Proposed Redevelopment of the Eastlakes Shopping Centre Site

Review of Traffic & Parking Matters

Prepared by
Fred Gennaoui

on Behalf of Department of Planning

Existing Thursday morning
peak hour traffic flows

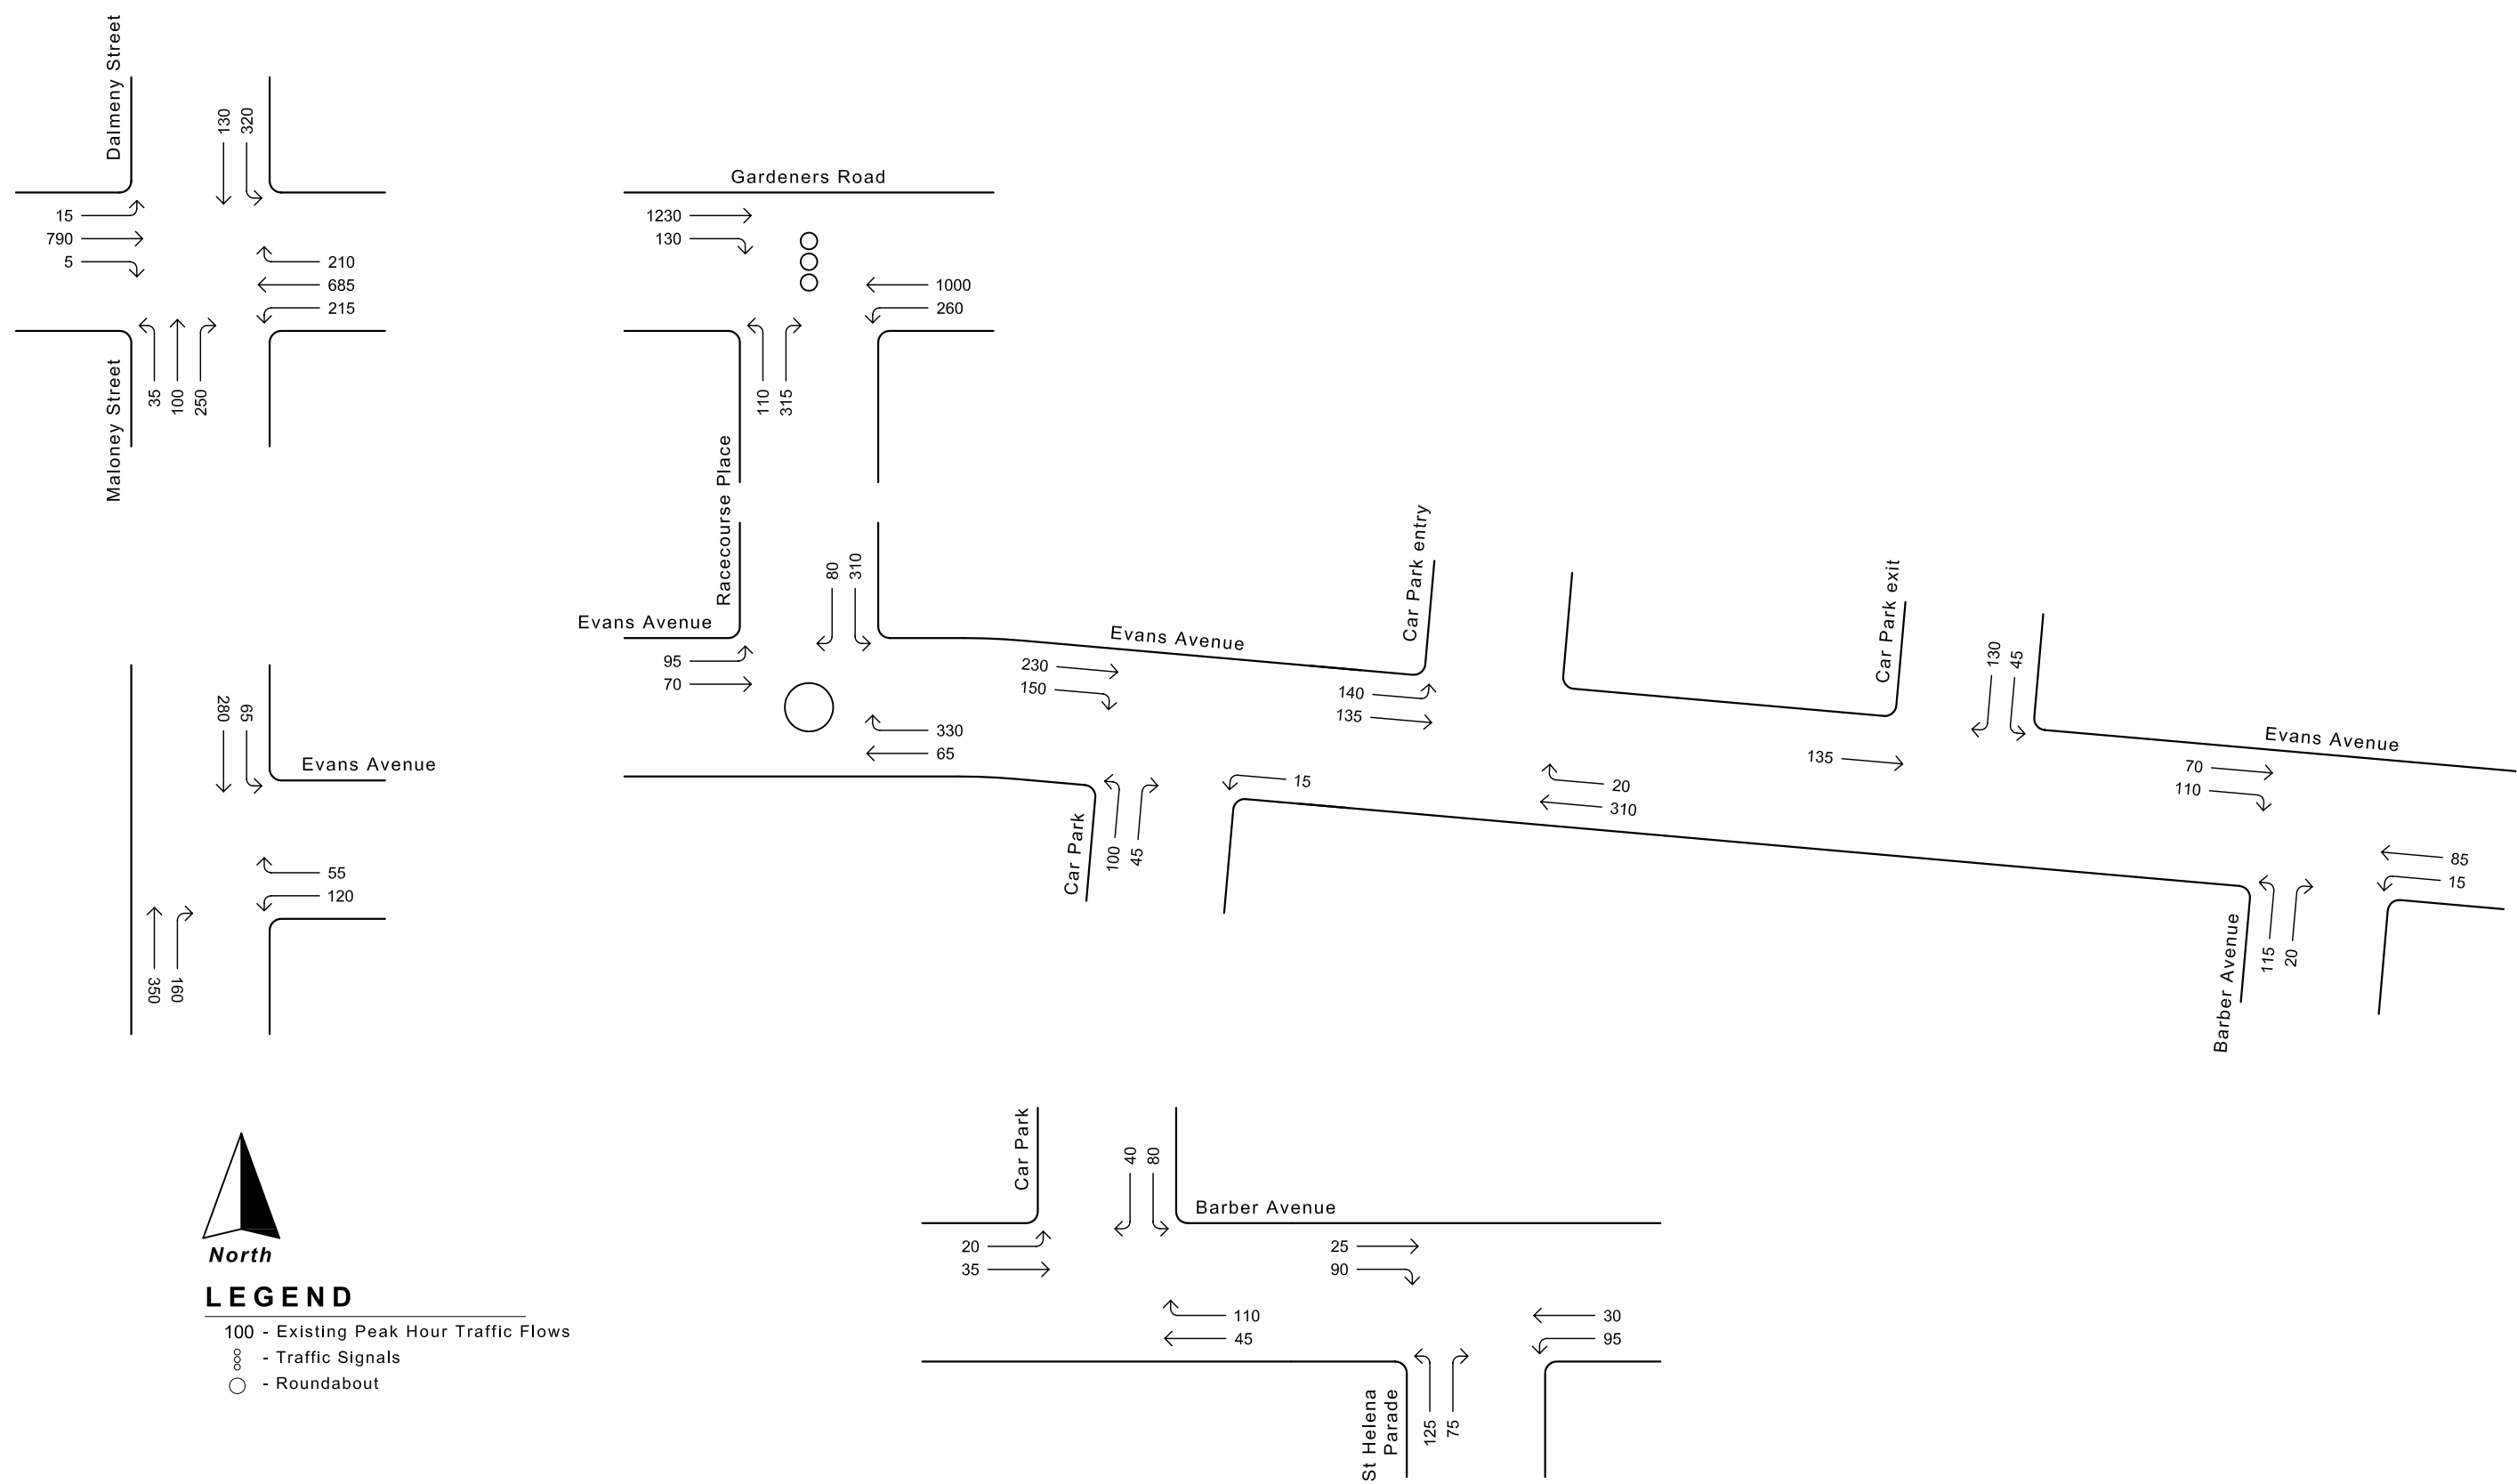
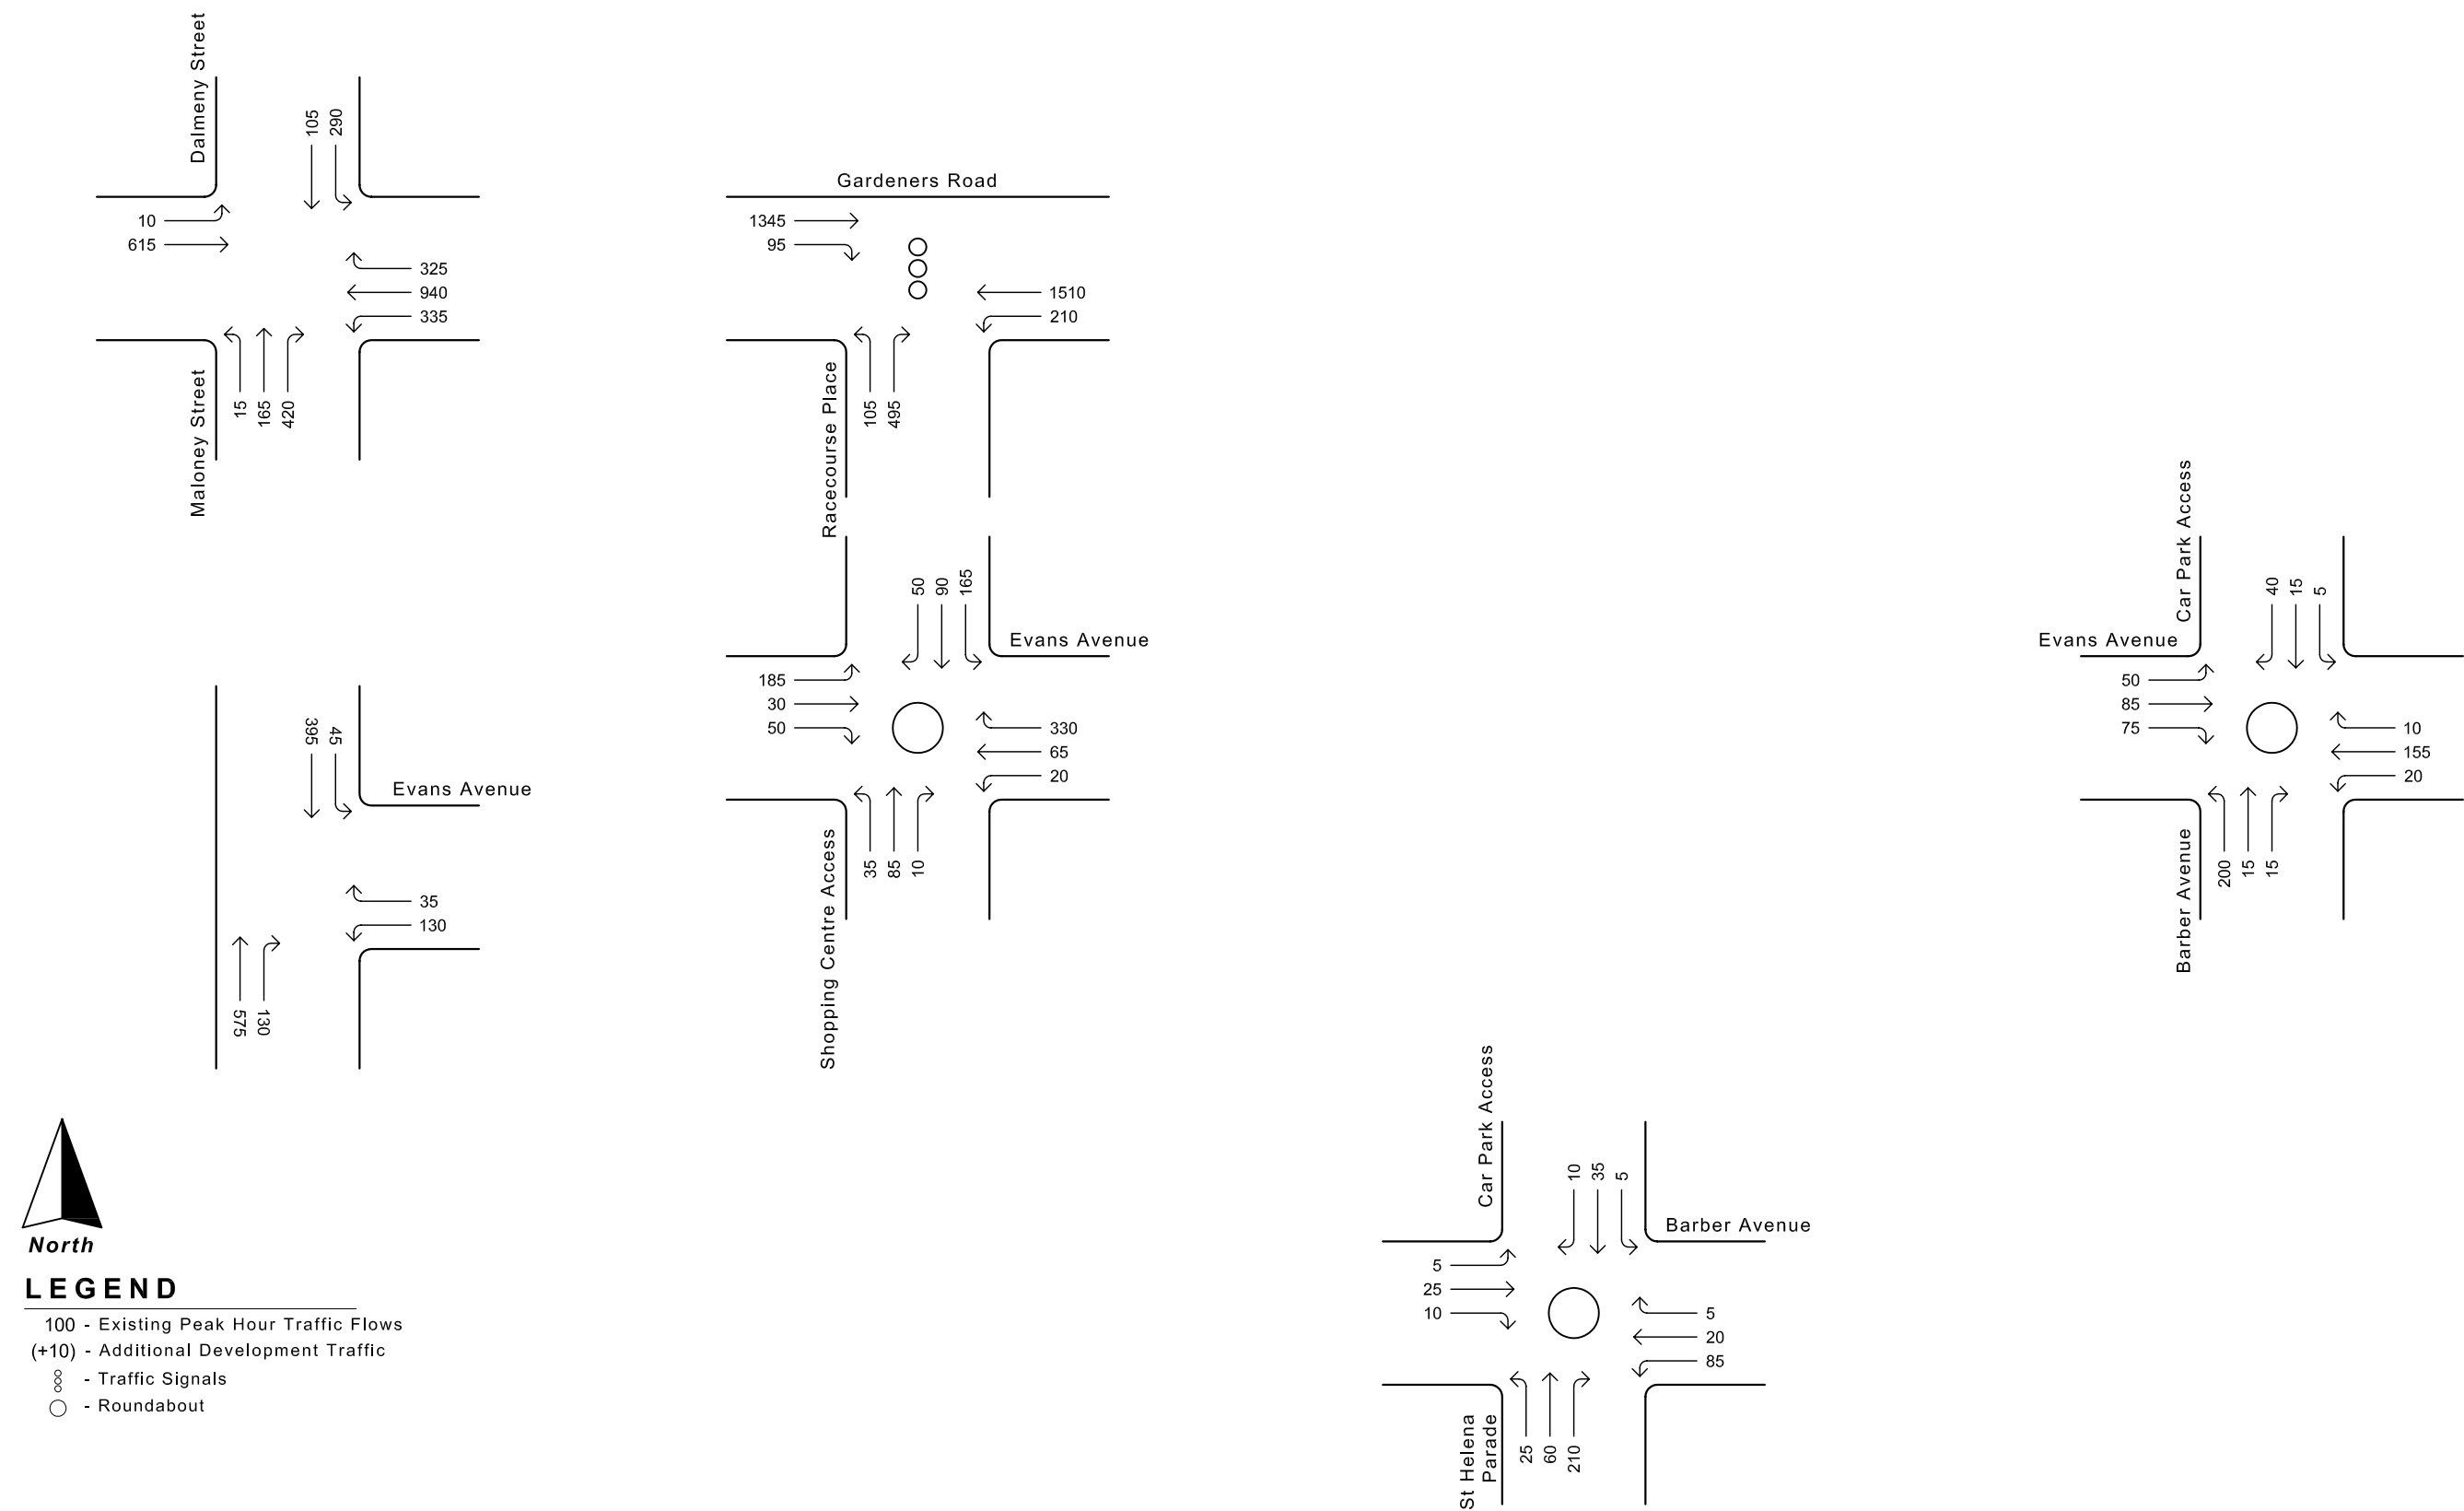
It is considered that these proposed access arrangements, which are currently required, would provide much better and safer access into a redeveloped site. Existing traffic volumes accessing the Centre, shown in Figures 2 and 3 of CBH&K report, would be redirected as shown in Figures 4 and 5 of the report. The redirection made by CBH&K of the existing traffic and the assignment of the additional traffic is considered reasonable.
